# CITY OF ALBUQUERQUE

**Re: Frank Sanchez Warehouse**  
**2339 2<sup>nd</sup> St., SW**  
**Request for Certificate of Occupancy- Transportation Development**  
Engineer's/Architect's Stamp dated 12-16-15 (M14-D029A)  
Certification dated 4-8-16

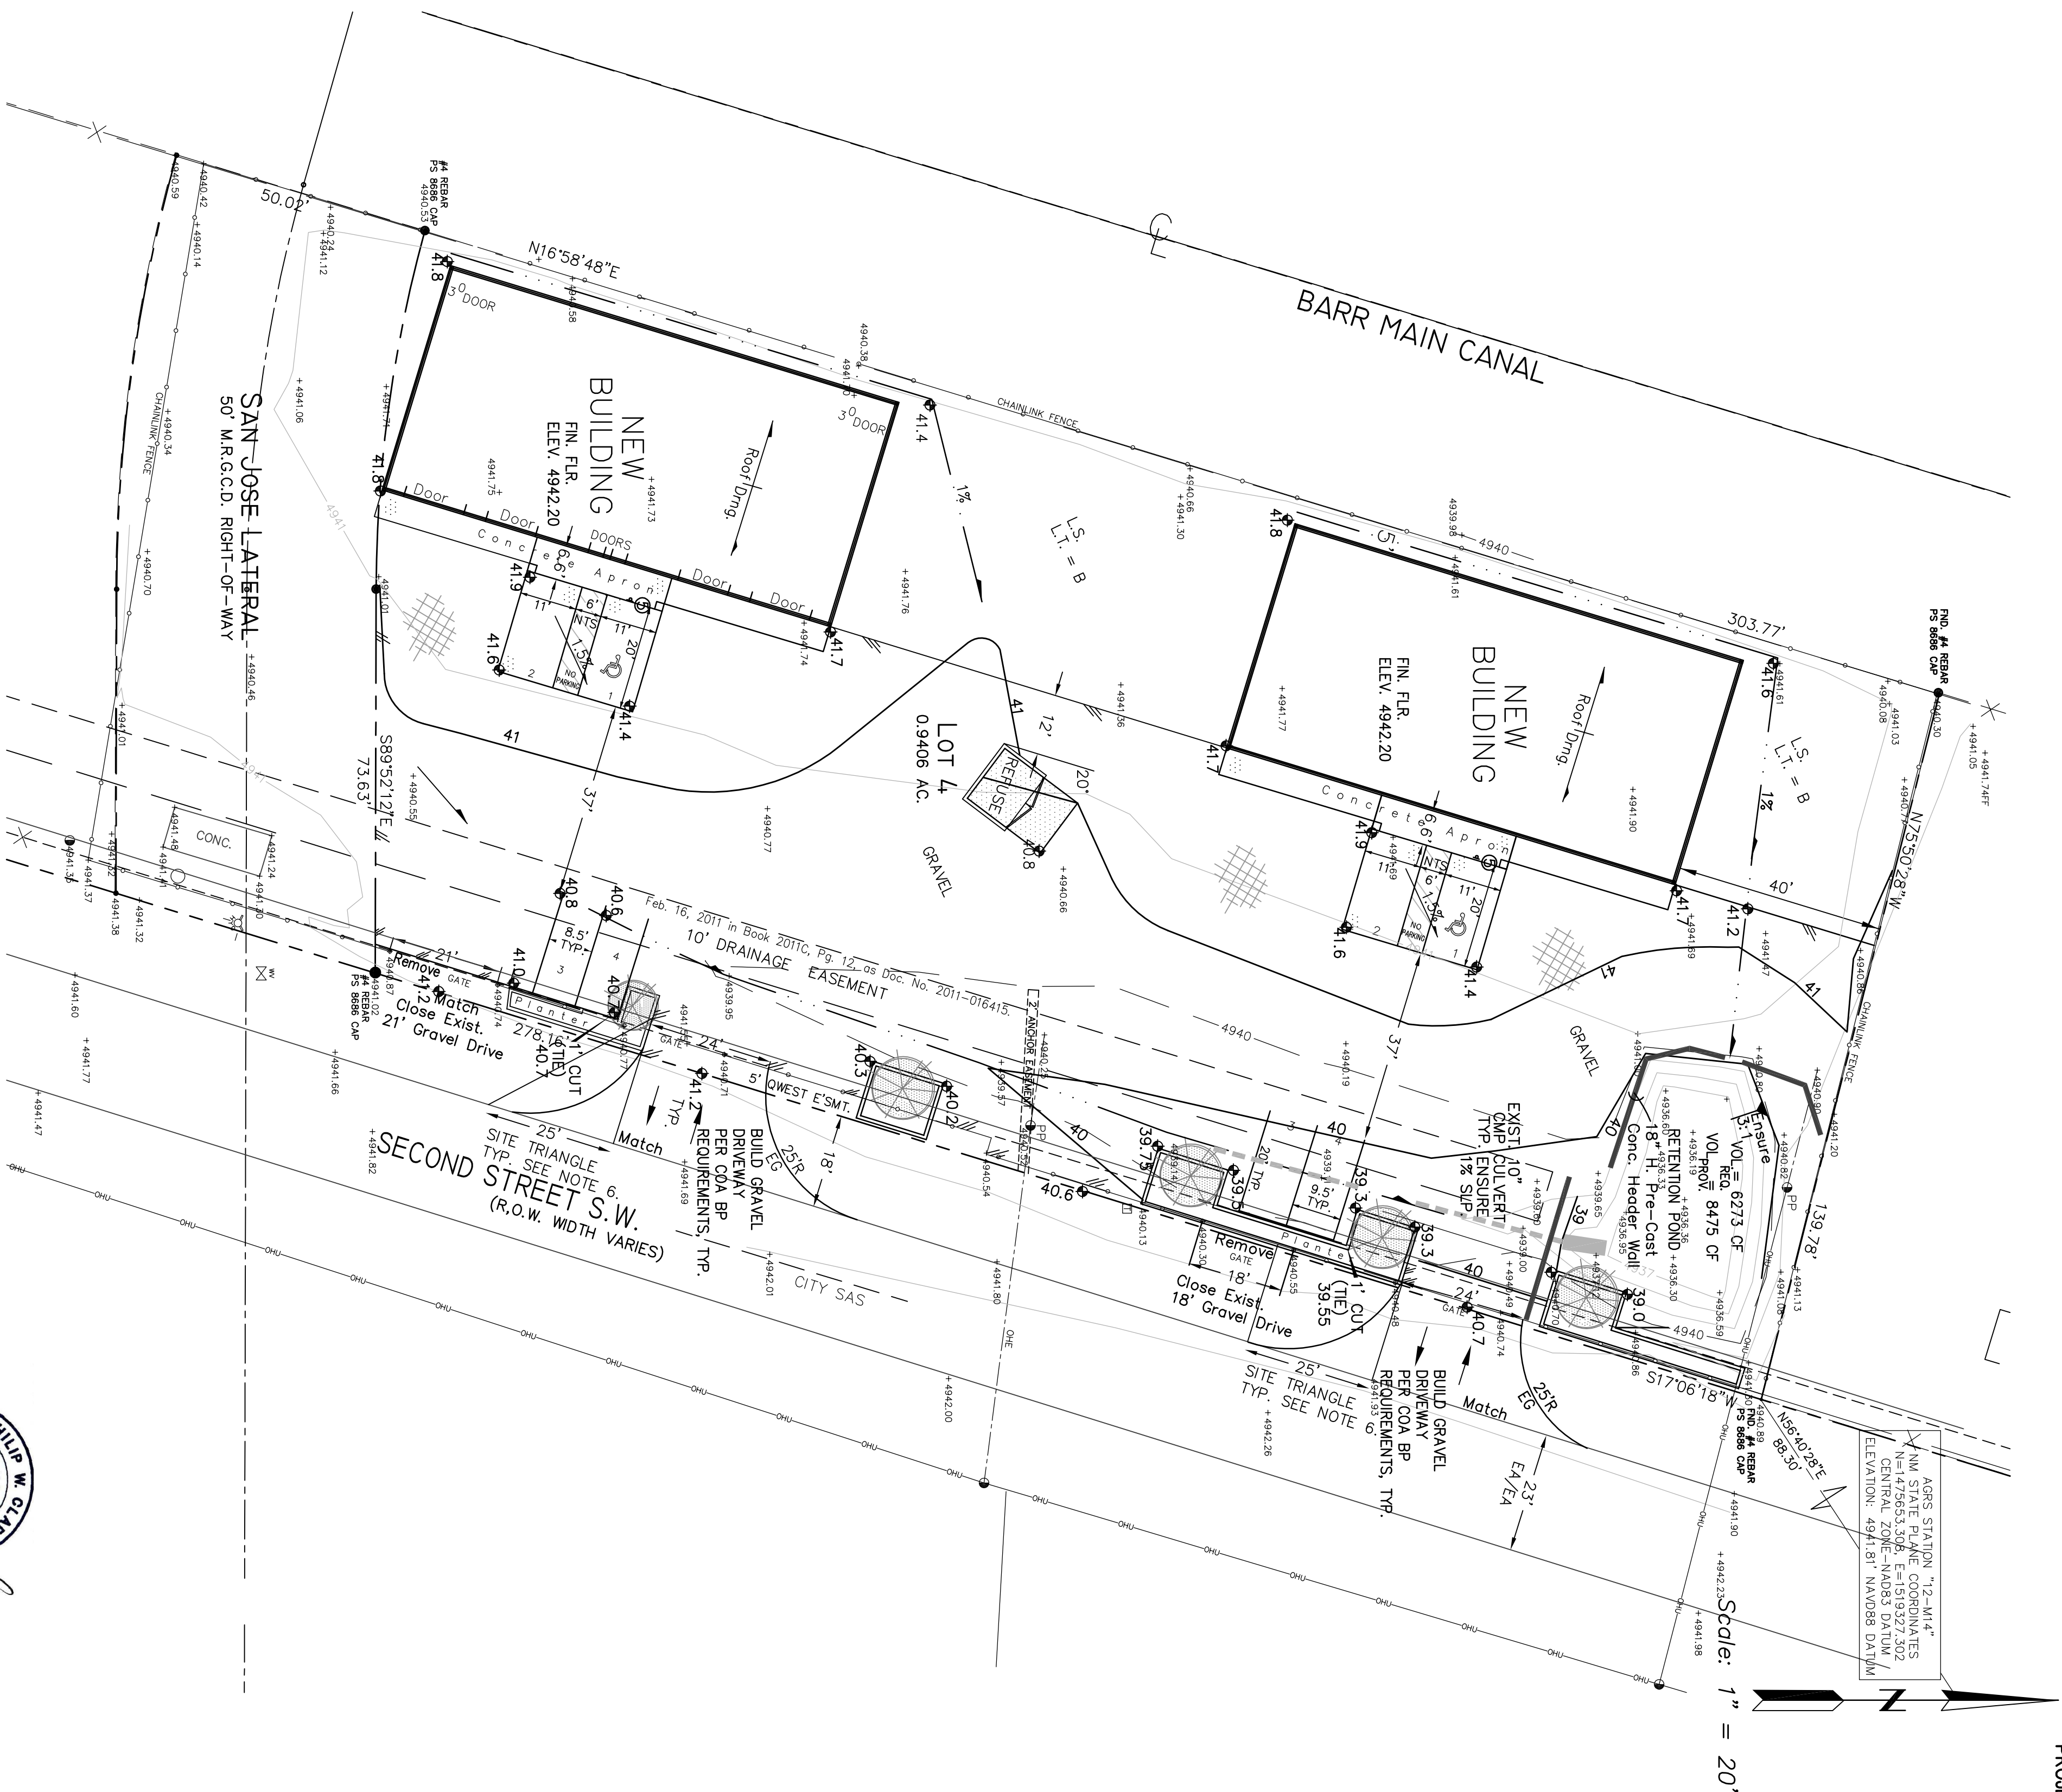
- Completion of ADA parking, access isles and installation of HC signs.
- Completion of Trash Refuse Container and approval from Solid Waste.
